CITY OF ALBUQUERQUE

Re: Philip Lovato & Sons
4101 4th St NW
Request Permanent C.O. - Accepted
Engineer's Stamp dated: 7-6-14 (G14D085)
Certification dated: 9-22-14

Project Title: LOVATO, PHILIP & SONS 4101 4TH ST Building Permit #: _____ City Drainage #: 614D085

Designed JSM	Drawn STAFF	Checked JSM	Sheet	1	of	1
File	LOV0114L	Date	FEBRUARY 2014

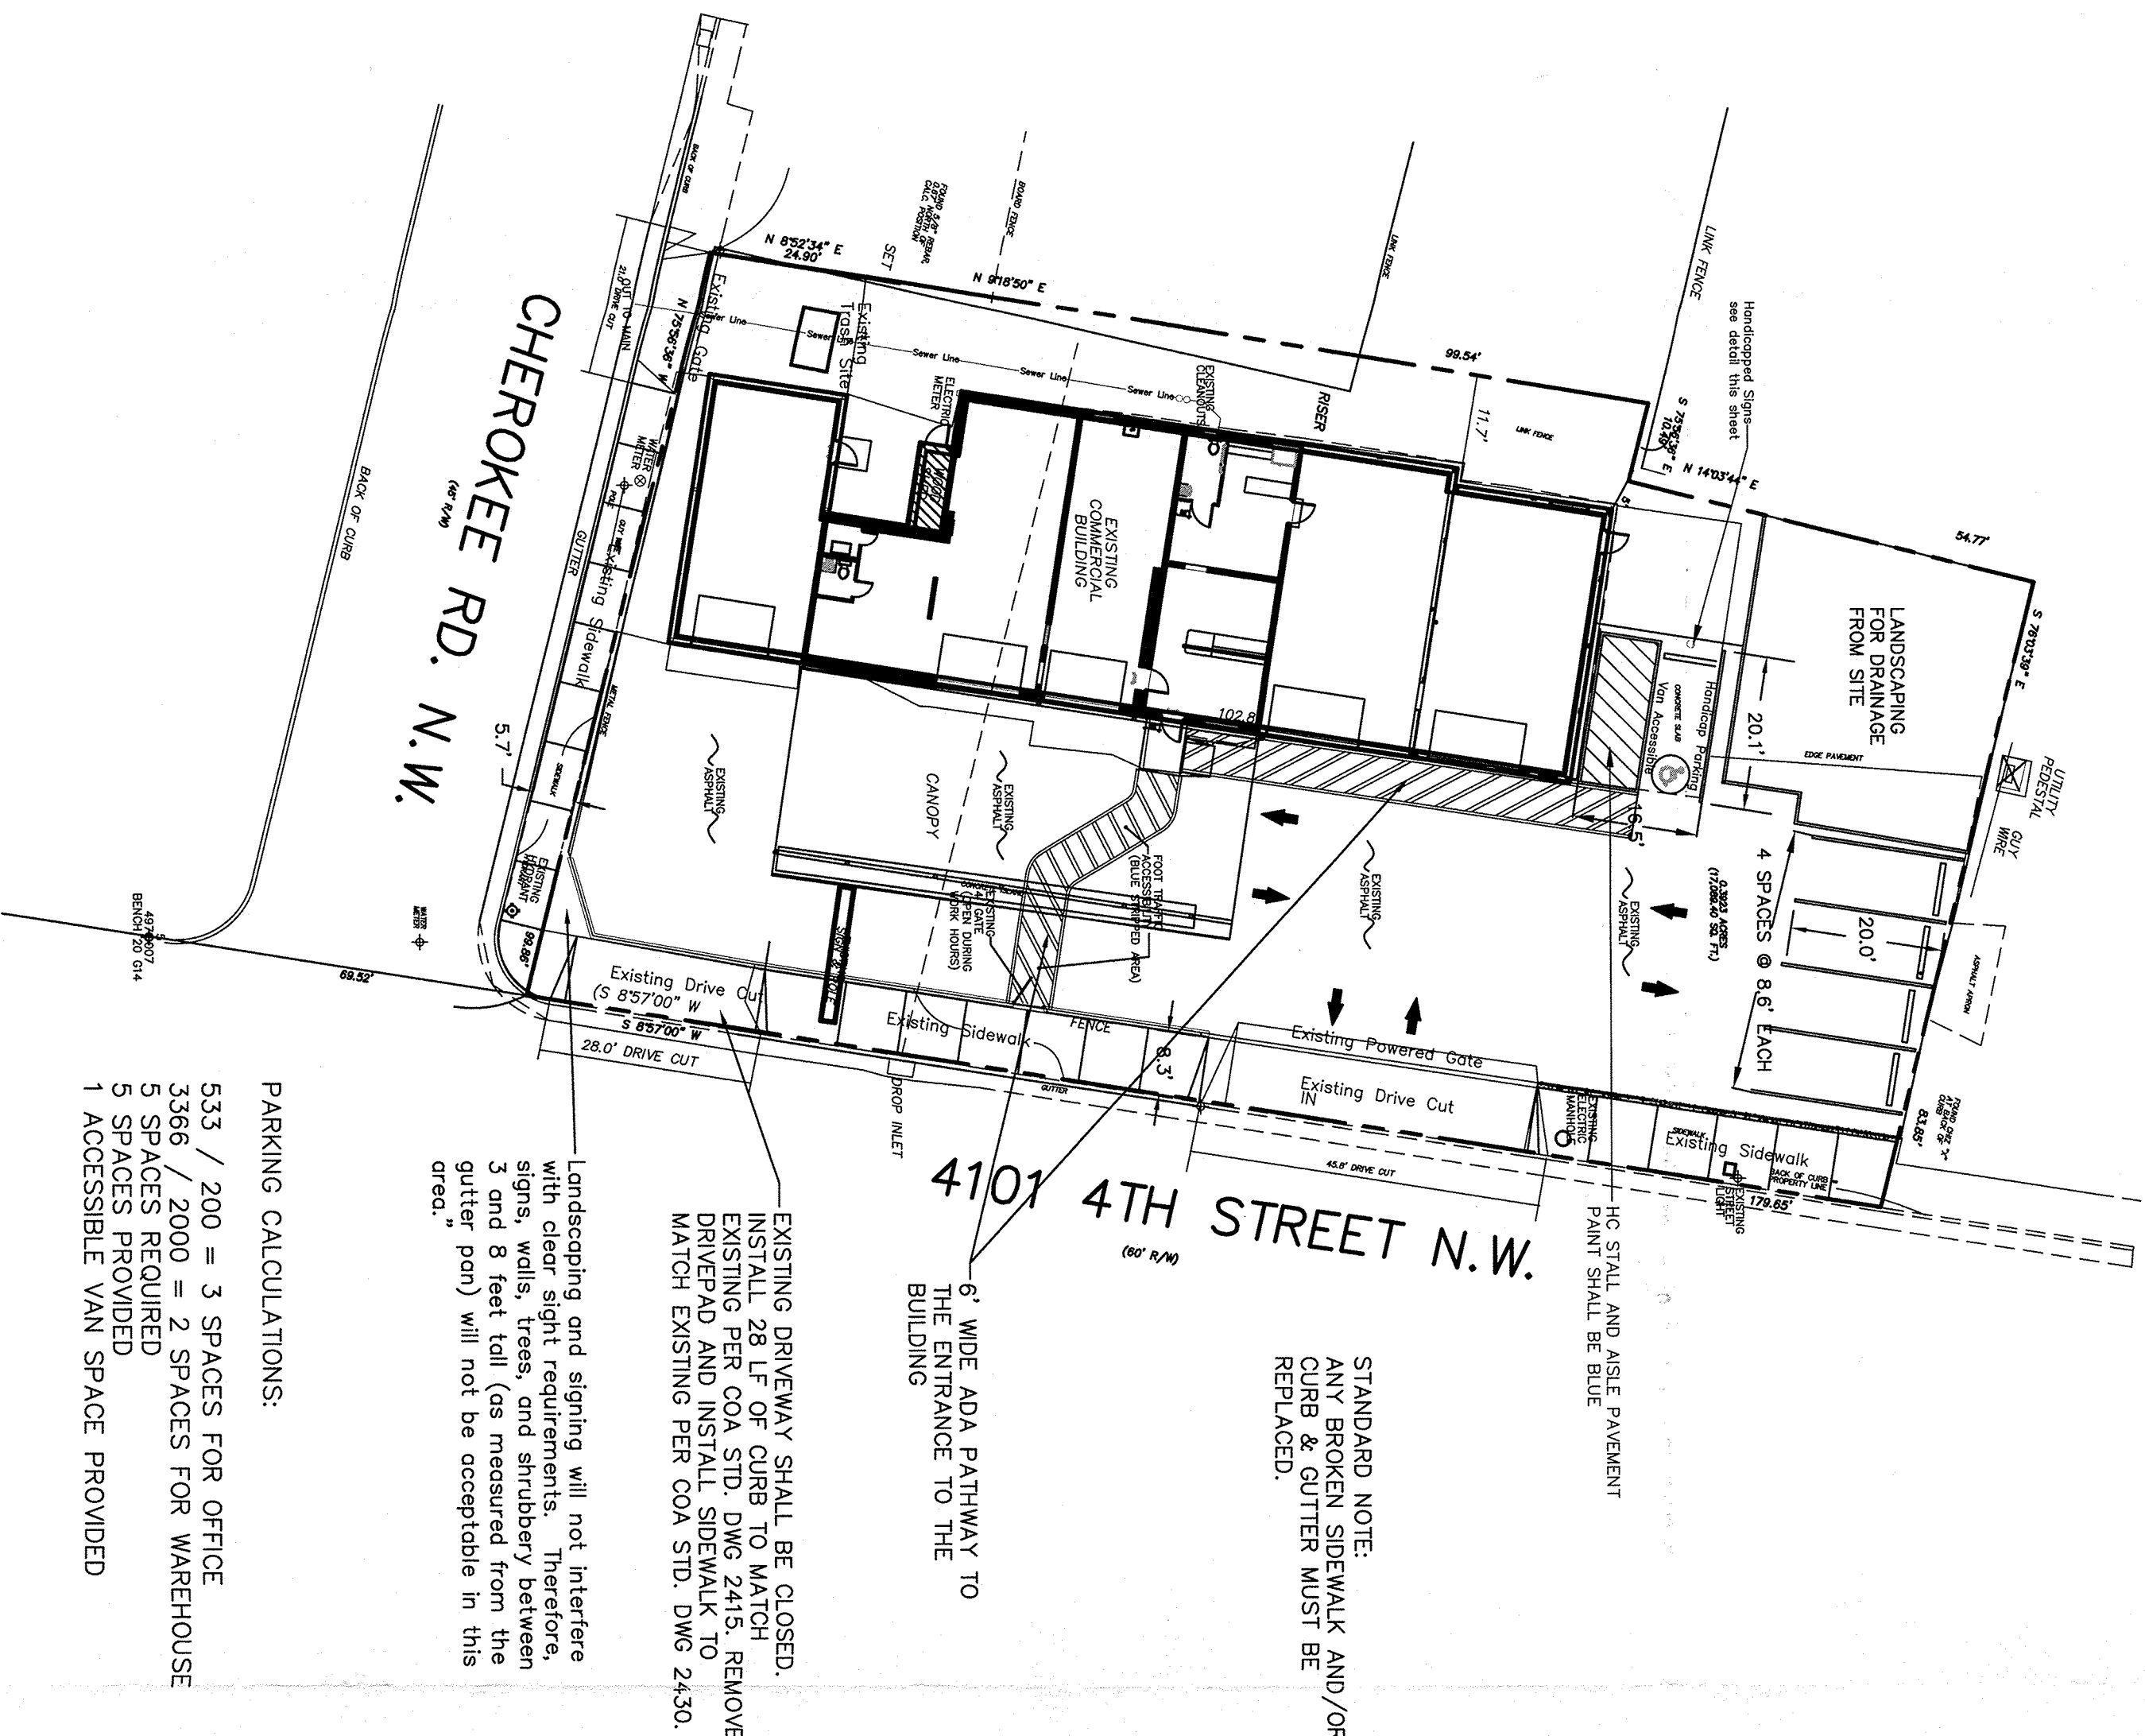
1. The development of this site must be in compliance with current DPM and ADA standards and regulations.
2. This site falls within the purview of the North Fourth Street Rank III Corridor Plan.

3. City Of Albuquerque Right-of Way dedication may be required.
4. Are the 7 lots going to be consolidated into one lot?
5. Zoning requests a meeting to review site for compliance.

6. Is landscaping required by zoning? If so, please provide landscaping plan with next submittal. Per the *Development Process Manual*, Chapter 23, Section 7, Part B.6, curbing should be used to separate landscaping from parking areas and pedestrian ways as well as providing a physical perimeter for harvesting water. This must be clearly shown on the TCL.

7. Please add the following note: "Landscaping and signing will not interfere with clear sight requirements. Therefore, signs, walls, trees, and shrubbery between 3 and 8 feet tall (as measured from the gutter pan) will not be acceptable in this area."

8. The existing fence may be within the COA ROW. If so, an encroachment agreement with the City may be required.
9. The existing sign and pole may be within the COA ROW. An encroachment agreement with the City may be required.

10. The existing fence may interfere with the sight distance of the intersection. Please provide a sight distance exhibit (see the *Development Process Manual, Chapter 23, Section 3, Part D.5 Intersection Sight Distance*).

11. Per the DPM, a 6 ft. wide ADA accessible pedestrian pathway is required from the public sidewalk to the building entrances. Please label ADA and dimension.

12. Per the DPM, a 6 ft. wide ADA accessible pedestrian pathway is required from the HC parking stall access aisles to the building entrances. Please clearly show this pathway and provide details.

13. A five-foot keyway is required for deadend parking aisles.
14. Please list the width and length for all parking spaces.
15. It is not apparent what type of pavement surface is being proposed. A hard driving surface will be required as part of this proposed project for parking area and drive aisles.

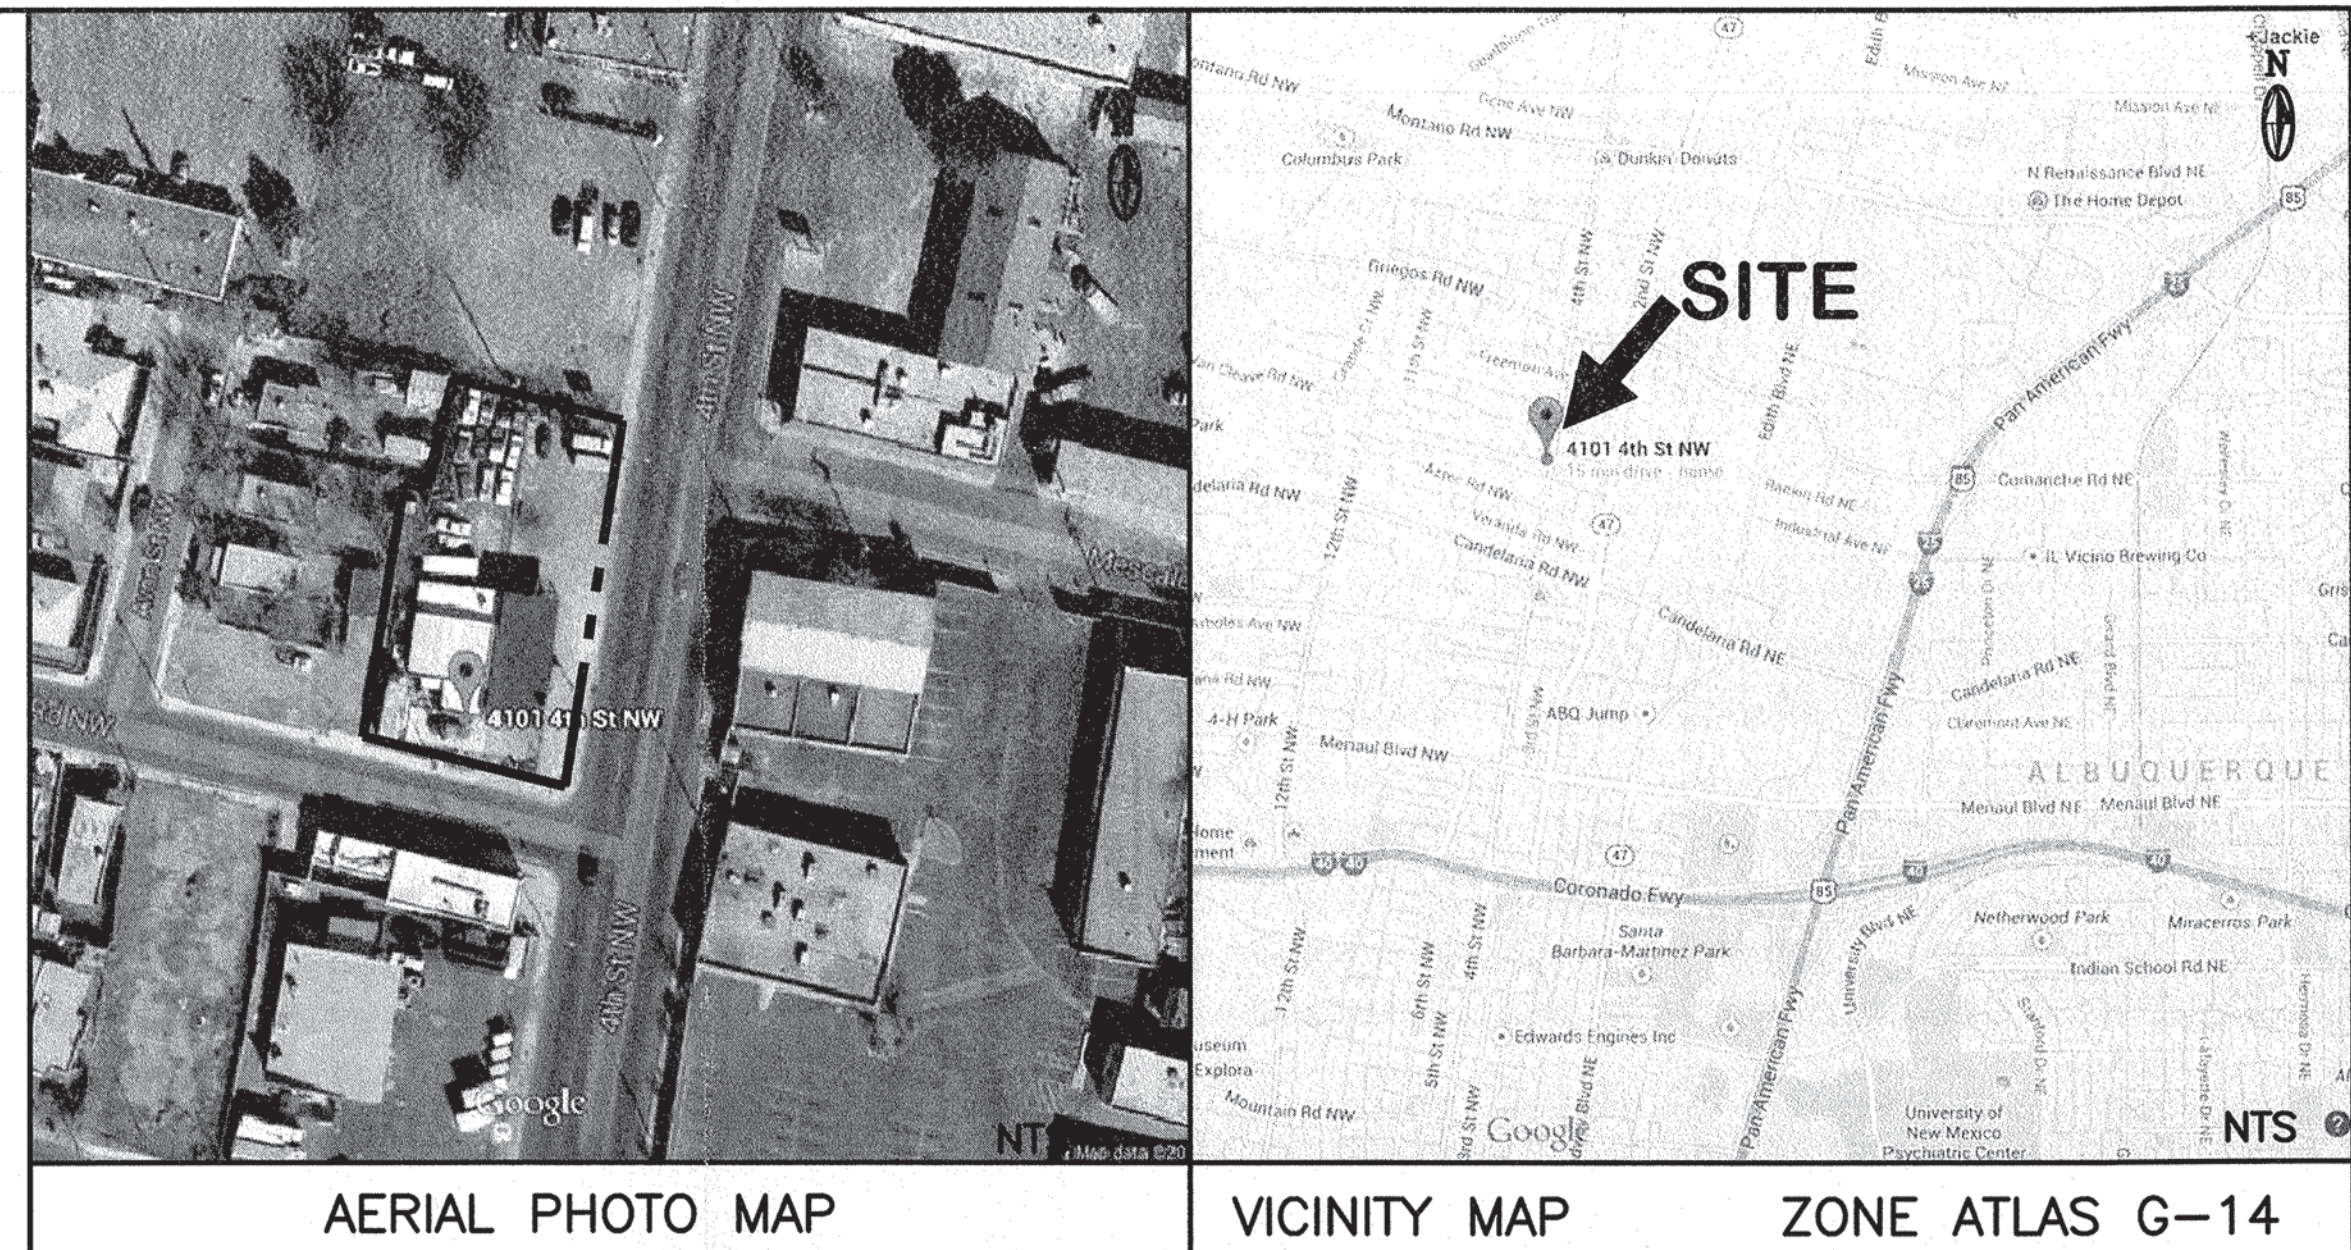
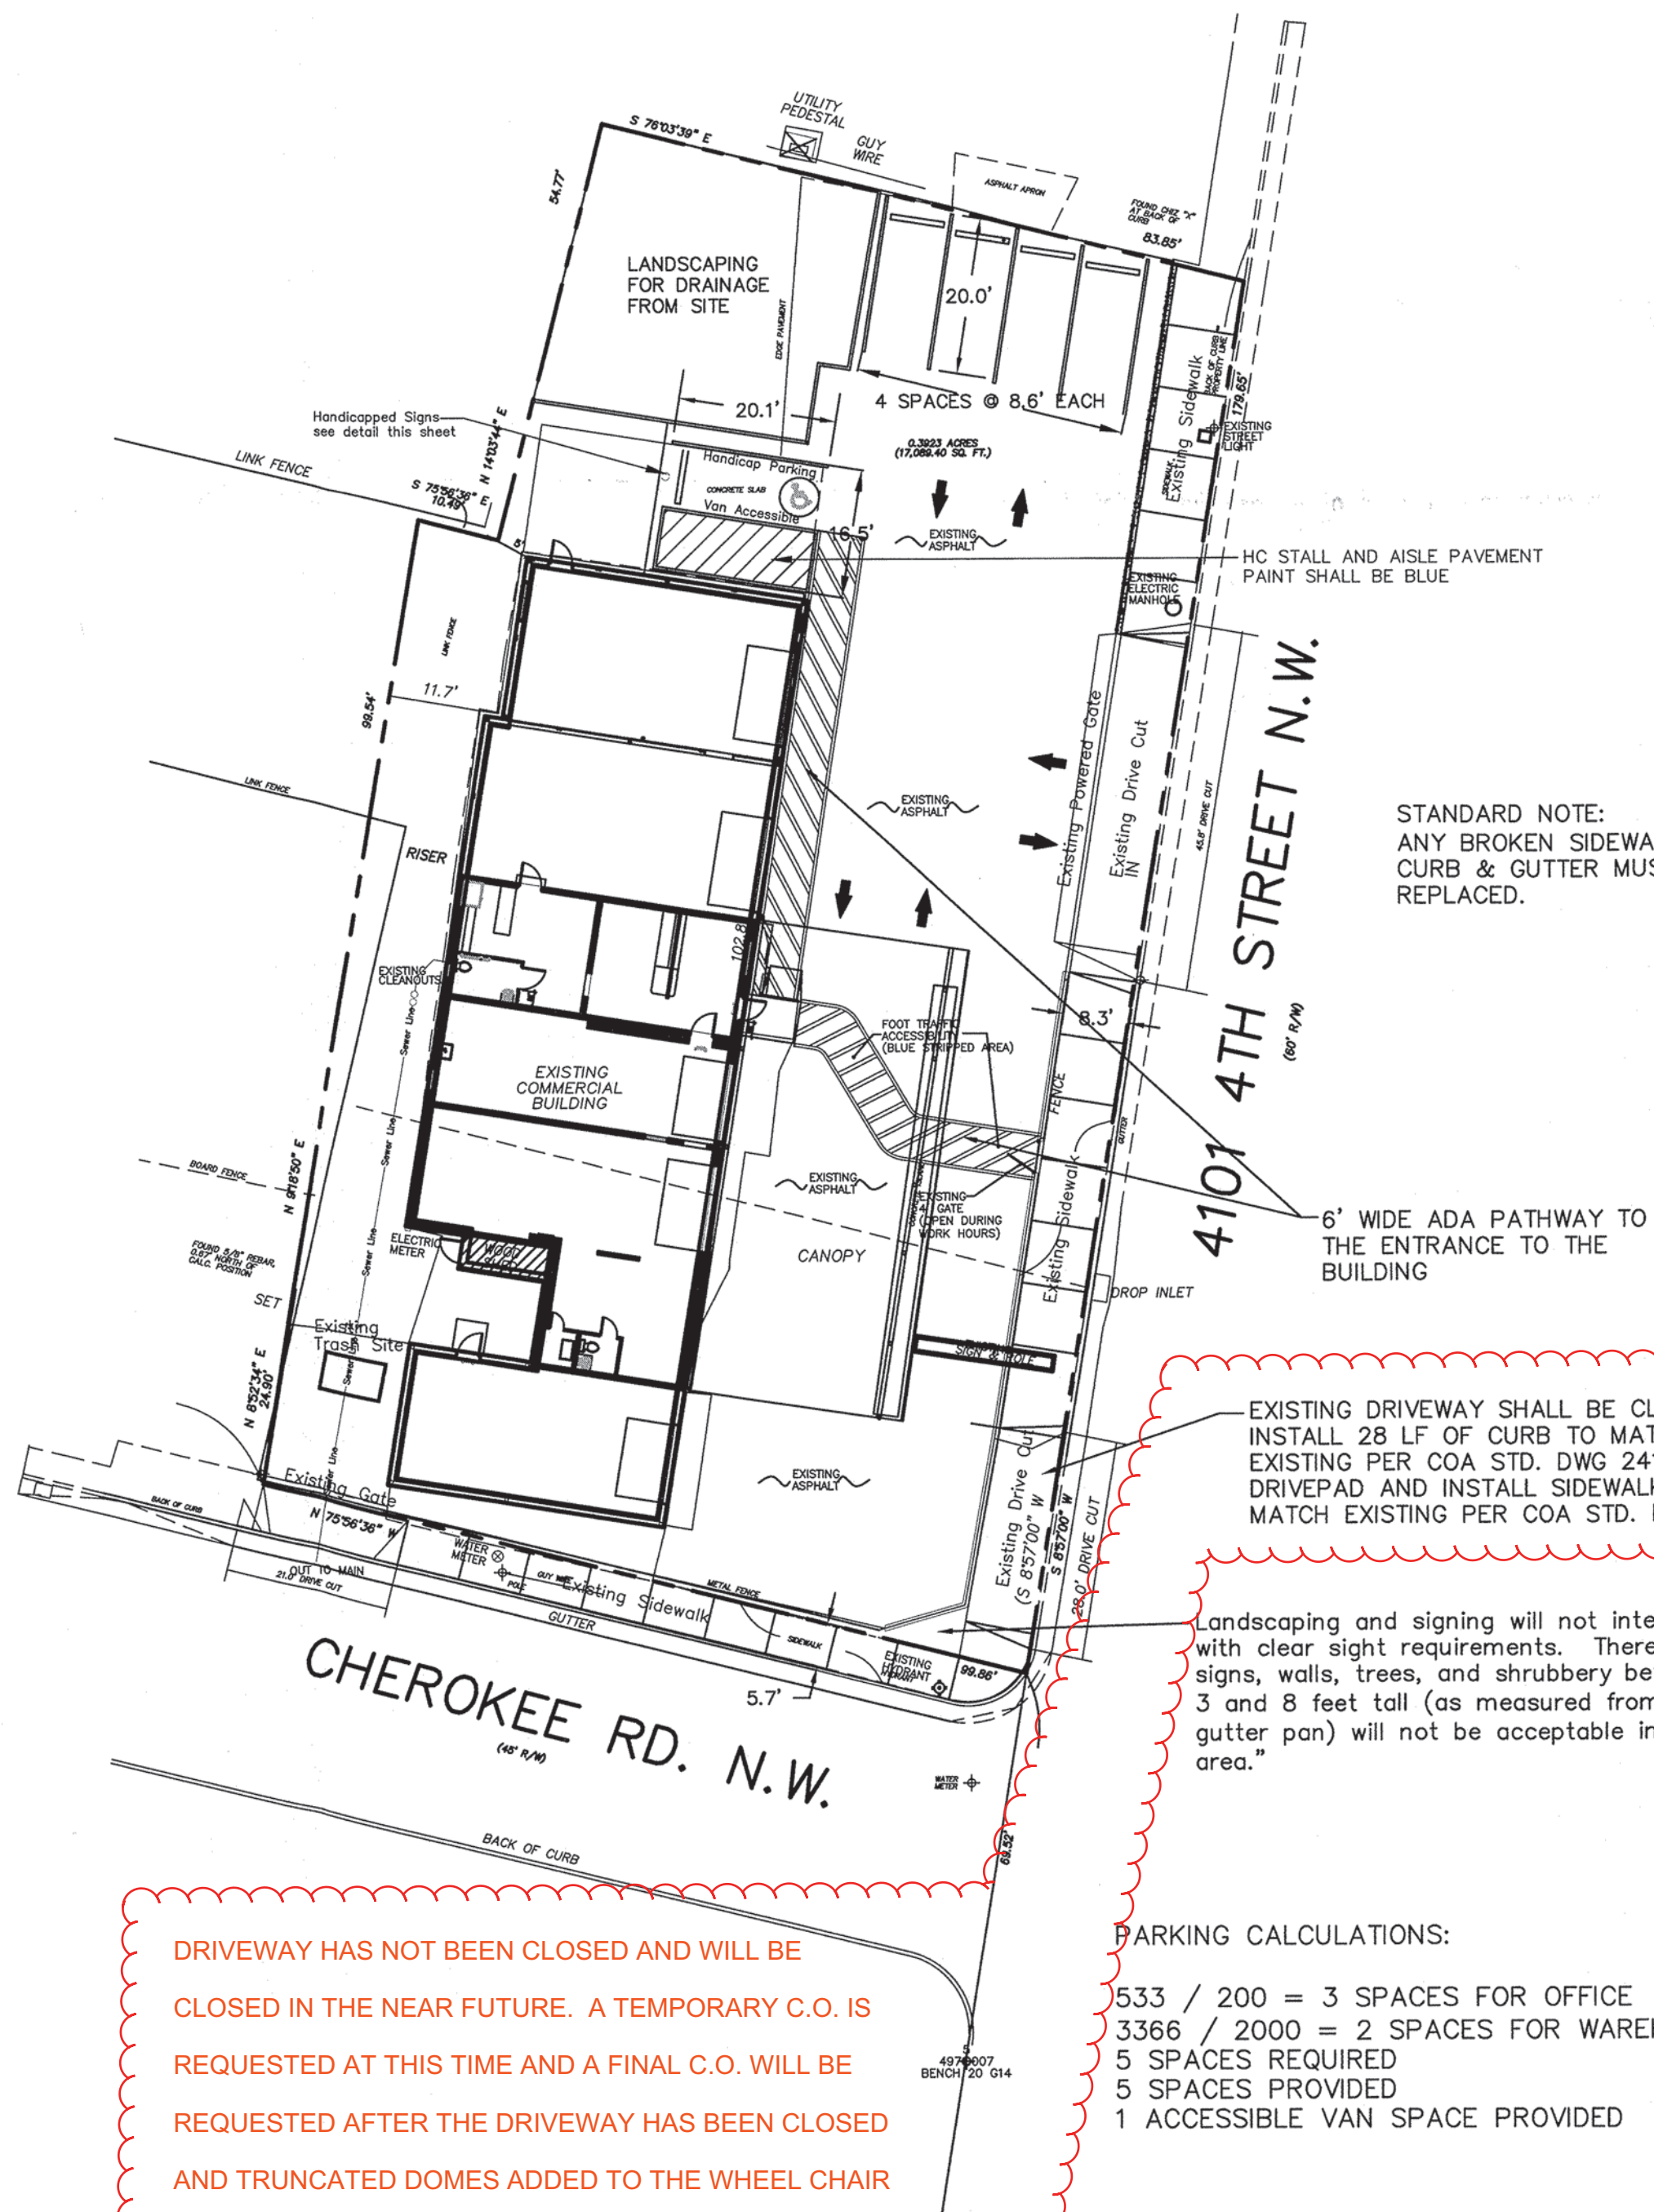
Prior to the issuance of a permanent Certificate of Occupancy, the following items must be addressed:

- The 28' driveway located on 4th street at the SW corner of the site needs to be closed and replaced with standard curb, gutter and sidewalk.
- Remove bollards located in the public right of way at the SW corner of the site and install truncated domes on the corner ramp.
- Ensure that the dumpster is in the location shown on the site plan.
